Your ref:	6 Grafton Street Condt 12 18...	<b>Please reply to:</b>	<b>Central Planning Team</b>
Our ref:	21/03906/ADFULL	Tel No:	2514
		Fee Queries:	0207 641 6500;
		Email:	planningreception@westminster.gov.uk;
Mrs Arran Dallimore C2J Planners UNIT 1A COMPASS BUSINESS PARK PACIFIC ROAD OCEAN PARK CARDIFF CF24 5HL United Kingdom		<b>Incomplete Applications</b> Development Planning City of Westminster PO Box 732 Redhill, RH1 9FL	
		29 October 2021

**Address: 6 Grafton Street, London, W1S 4EQ,**

**Proposal: Details of waste storage and Operational Management Plan pursuant to conditions 12 and 18 of planning permission dated 23 January 2018 (RN: 17/07355/FULL).**

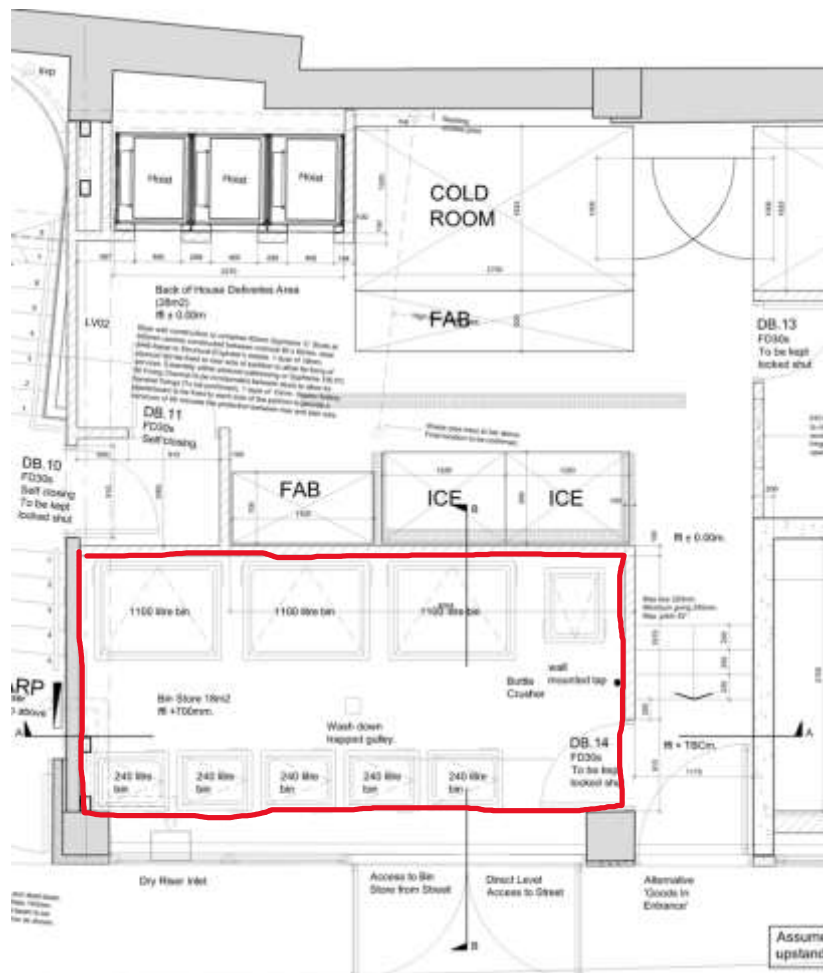
- 1 The waste provision shown in the Operational Management Plan (OMP) shows no more detail than that submitted in the original application. Although a bin store was indicated on the image within the OMP, the waste detail submitted are not in line with the council waste storage requirements. Three to four different waste streams are expected from this development which are food waste, waste cooking oil, general waste, and recyclable materials. The three or four waste streams must be stored separately in different bins. You need to confirm the bin capacity for each waste stream.

The bins should be indicated and labelled O (for food waste), WCO (for waste cooking oil), R (for recycling) and W (for waste) on the drawing. Please refer applicant to the City Council Recycling and Waste Storage Requirements

Please provide a drawing containing the above information.
